Please upload onto Ocella the email below which is a representation to planning application **A/76/20/PL** – Land West of Dappers Lane, Angmering.

The email from Robert Clark, Persimmon Head of Planning, relating to their updated external works plan for Application A/76/20/PL, posted on your website on 1st July 2020, states that they are proposing a 1.8m close boarded fence along the boundary with Herons Farm and along the southern boundary with Woodlands Close. In addition, however, the revised plan itself now also shows the 1.8m close boarded fence extending along the major part of the boundary with my property, Woodlands, but there is no reference to this in Persimmon’s email.

| External Works Layout |             |

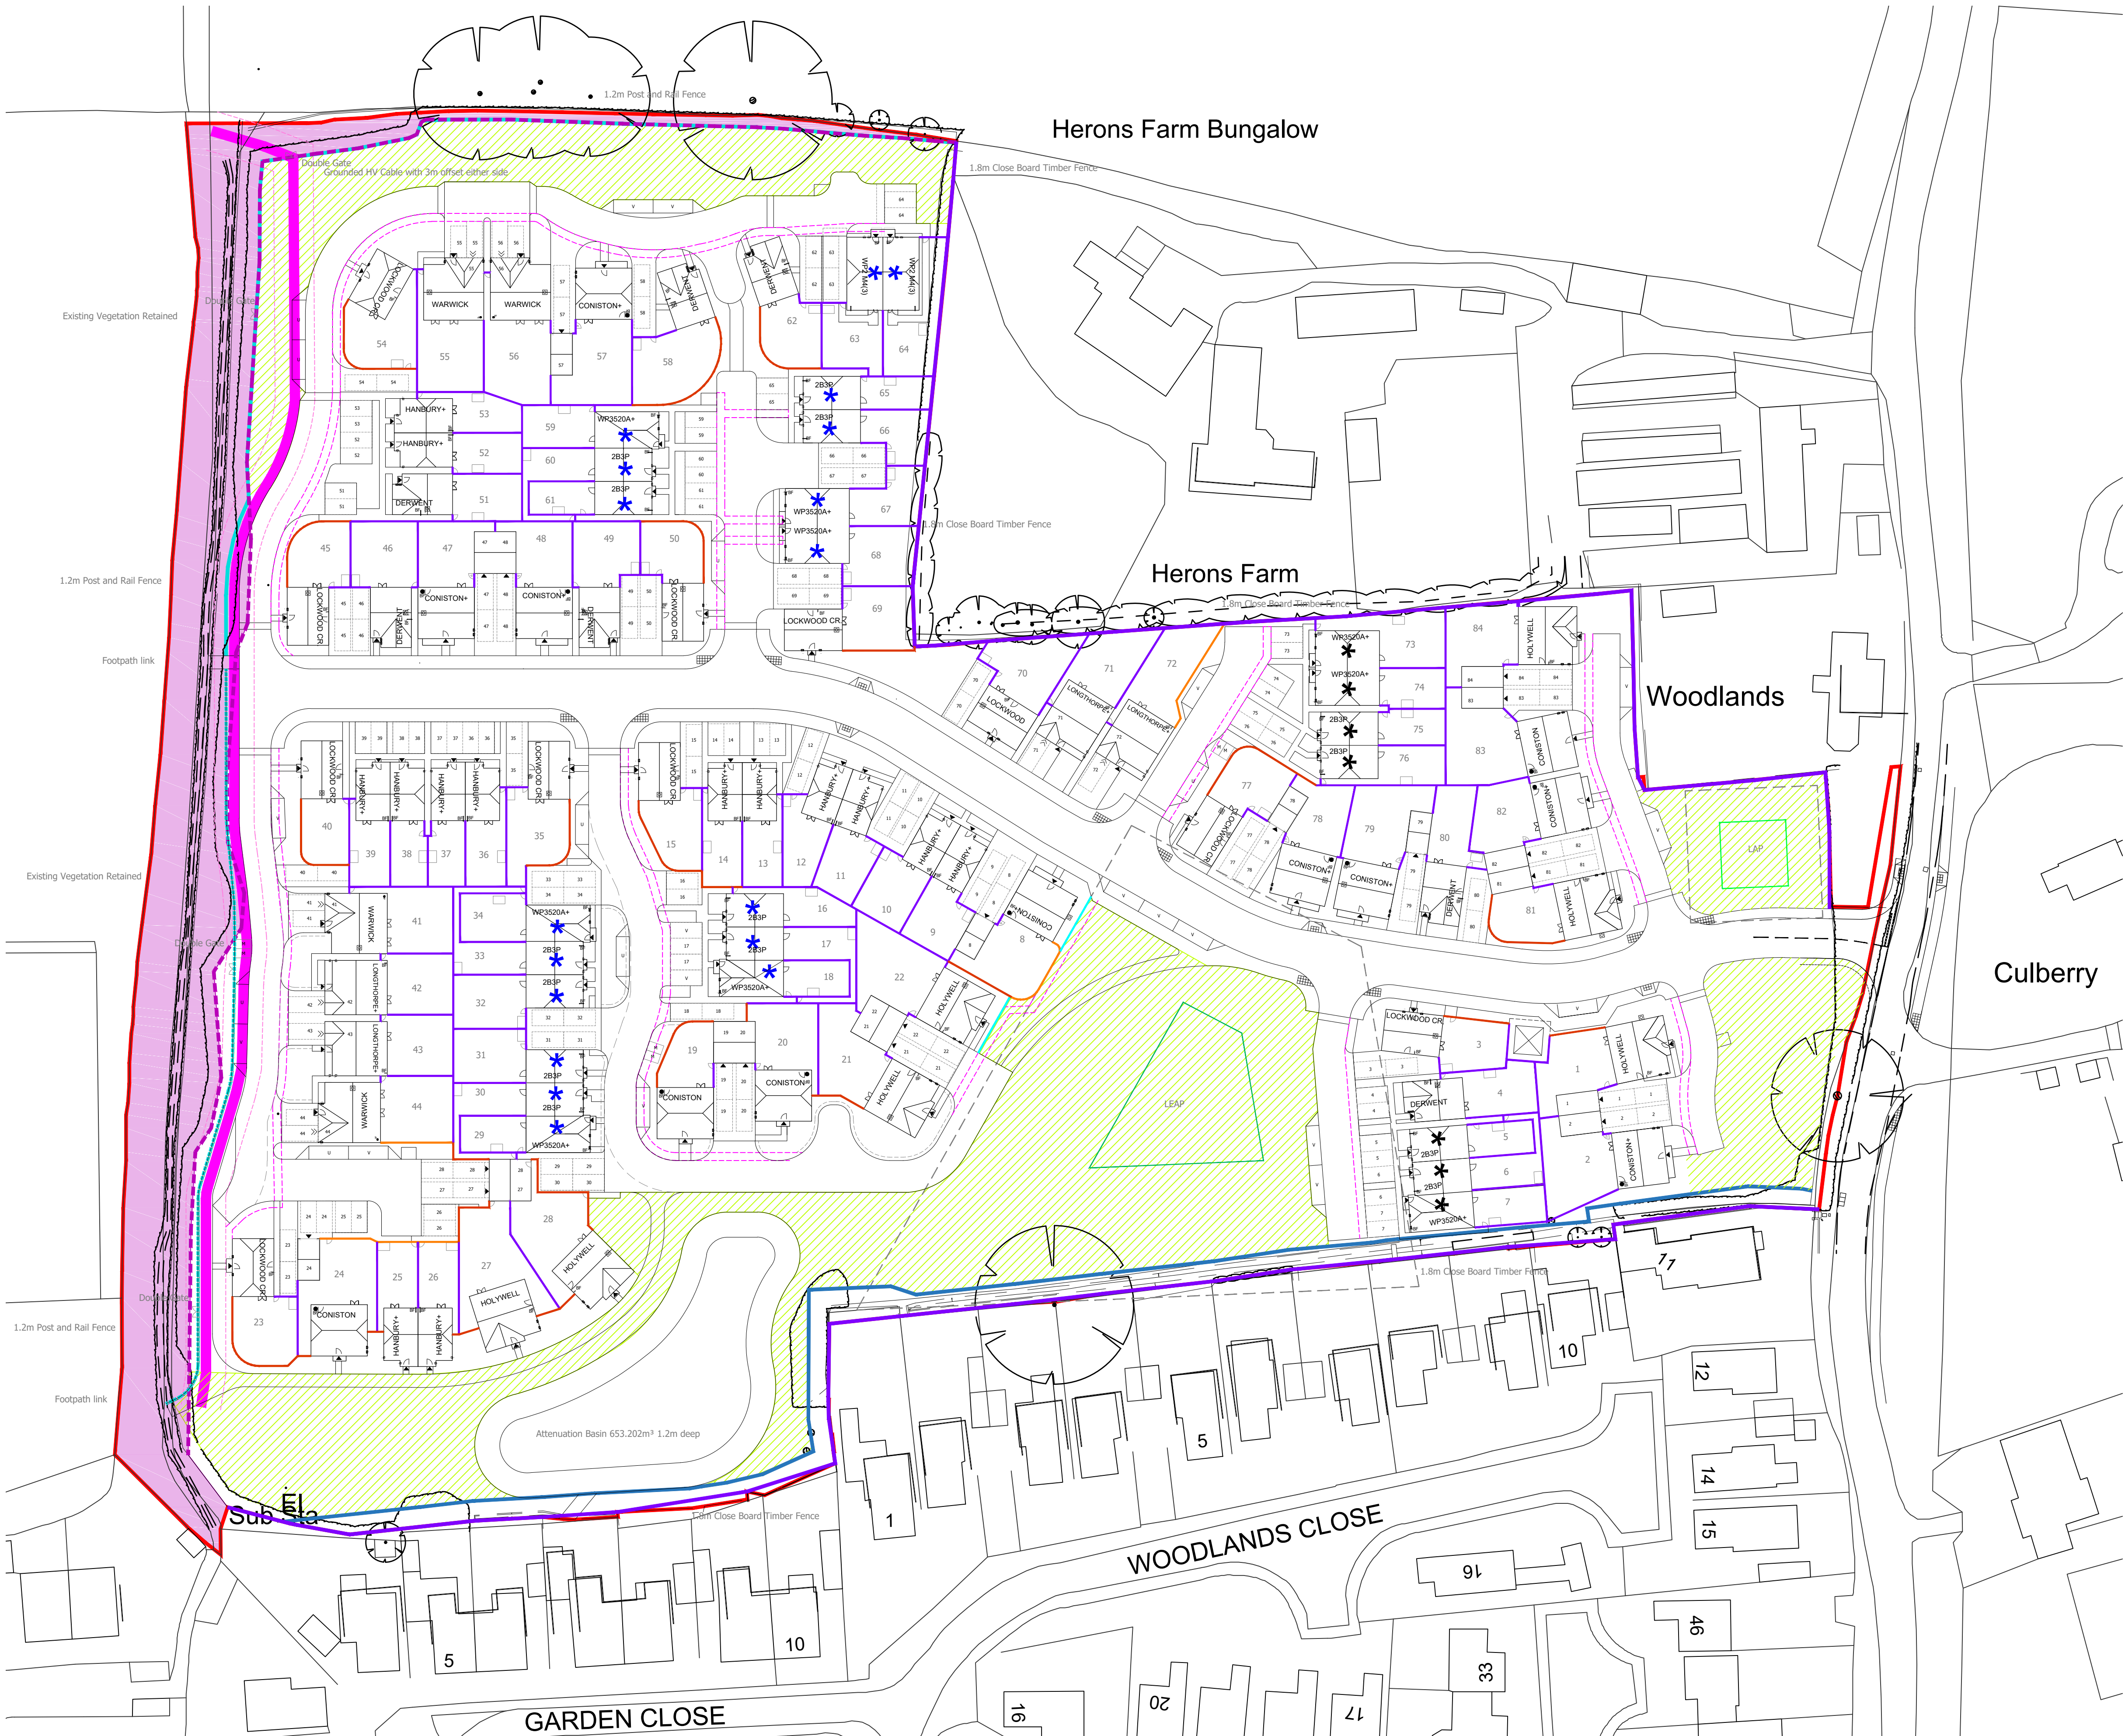
Wooden fencing is not appropriate for the boundaries of this development site due to the wet and frequently saturated ground, and it is particularly inappropriate to use wooden fencing as the boundary of the Local Area of Play adjoining my property. I would also ask it to be made quite clear as to who will bear legal responsibility for maintaining the close board boundary fencing both in the short and long term, should this option go ahead. Previous layout plans showed these boundaries to be 1.8m brick wall with tile crease top, and I am extremely concerned about the proposal to change to wooden fencing - this should most certainly be reversed.

In view of Persimmon’s proposed changes I would also ask for clarification as to their proposals regarding their other boundaries with my property (see attached plan borders A – B, B – C, and C – D), and their boundary with Dappers Lane (attached plan D – E), immediately to the north of the site entrance.
